9525 Burgess Road, TU-19-36

Please accept the following comments from El Paso County Public Health regarding the proposed Christmas Holiday Temporary Use:

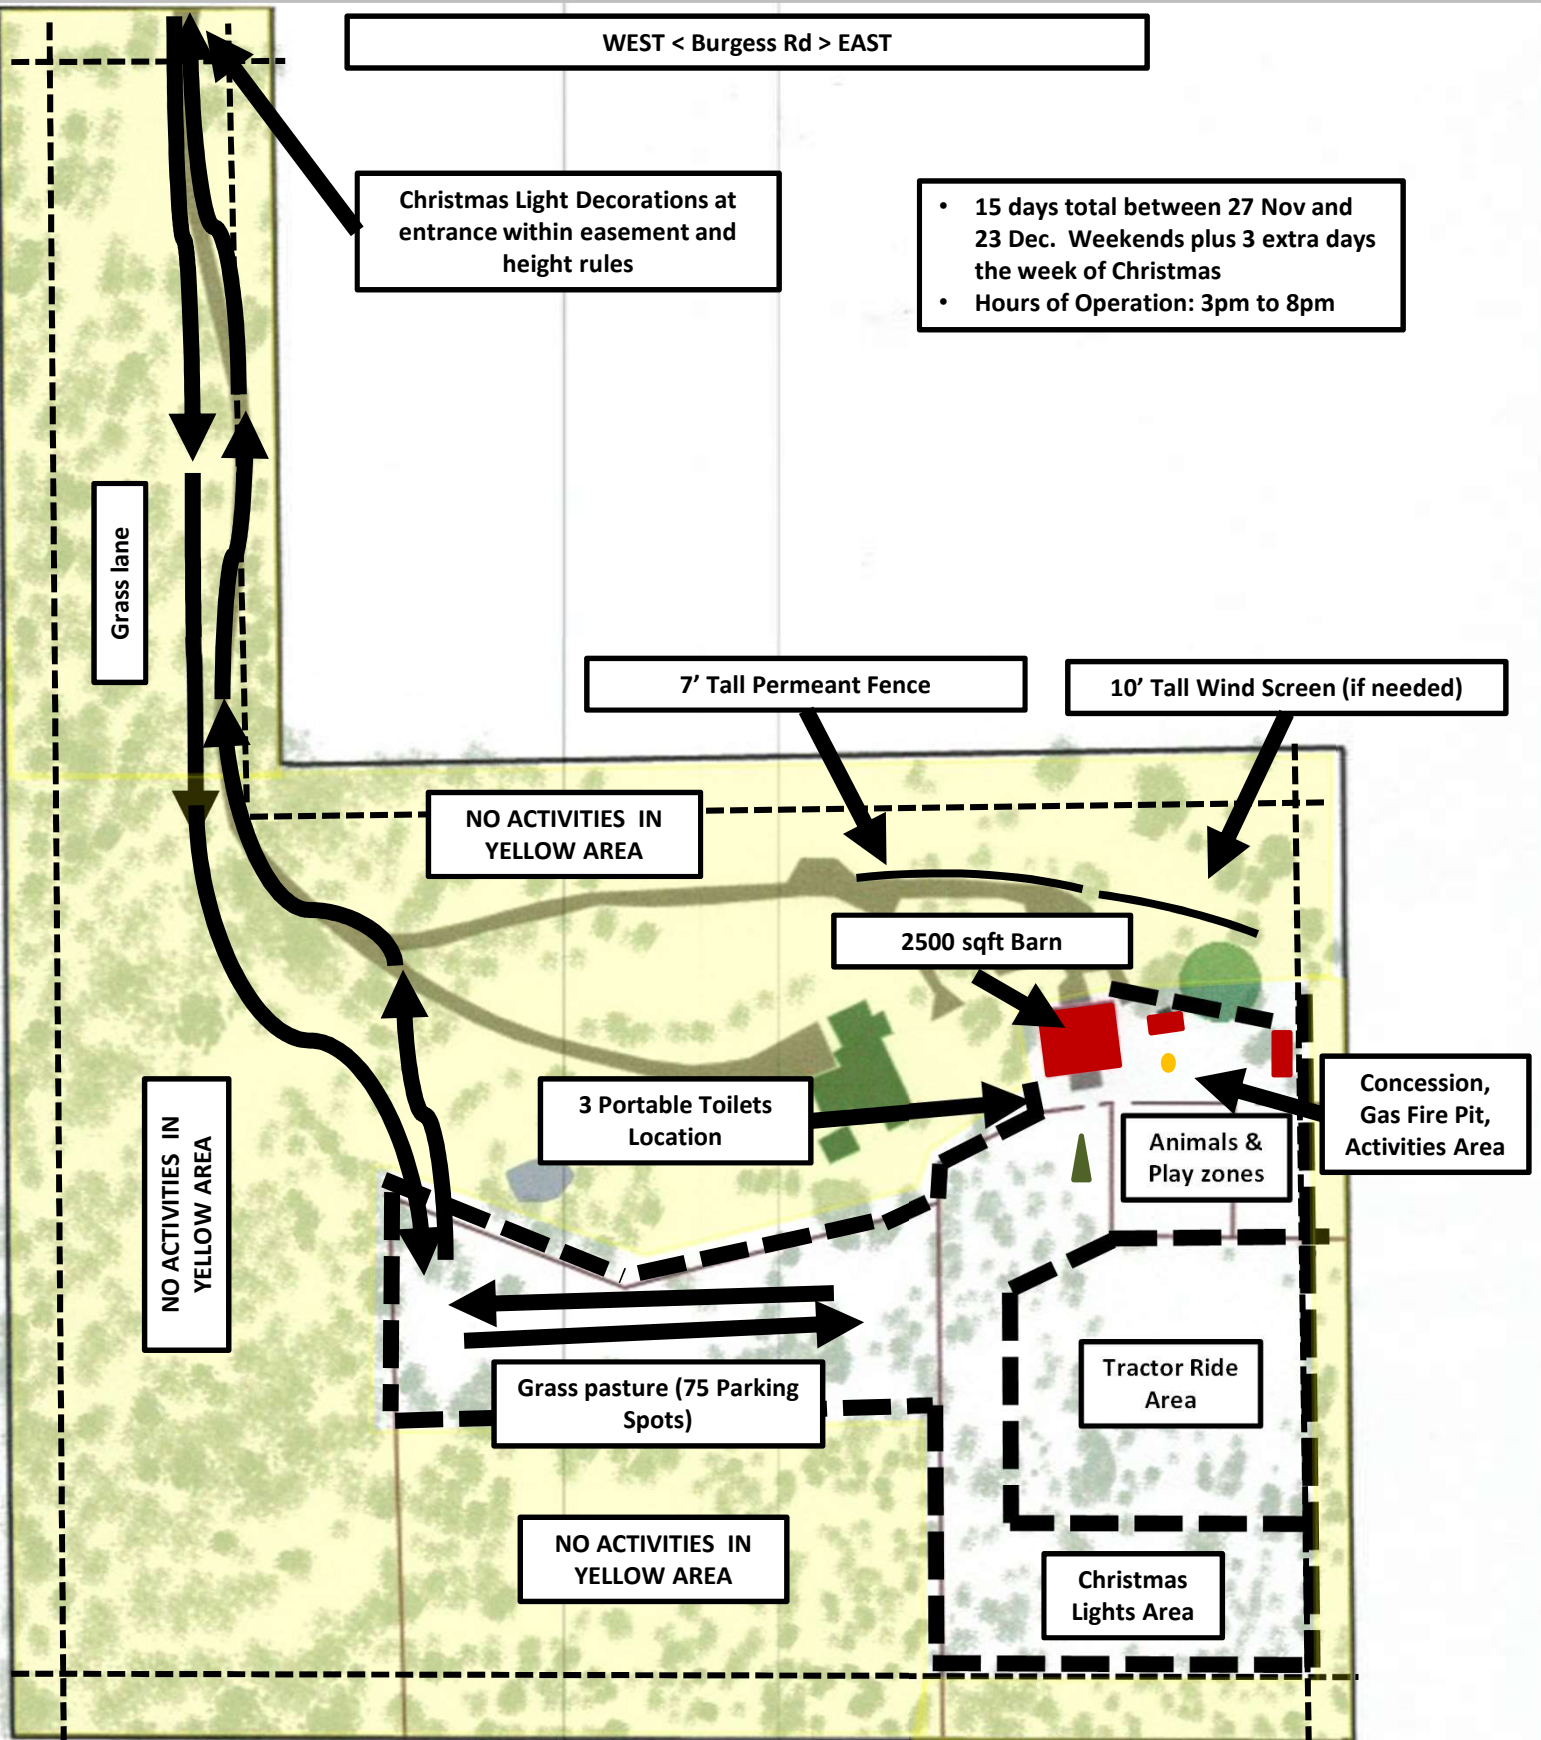
- **The COVID-19 group gathering requirements change frequently, not only locally, but nationally. Please be aware that an approval now does not guarantee approval in November and December. The owner is responsible for compliance with all group gathering requirements in effect at the time of the event.**
- **The concessions planned require input from El Paso County Public Health and may require changes on how food and beverages are served/handled. Call 719-578-3199 and select option 3 for Environmental Health and ask to speak to the Food Program Manager.**
- **The use of three (3) portable toilets with weekly servicing is acceptable. Recommend using a couple portable handsinks in addition to hand sanitizer.**
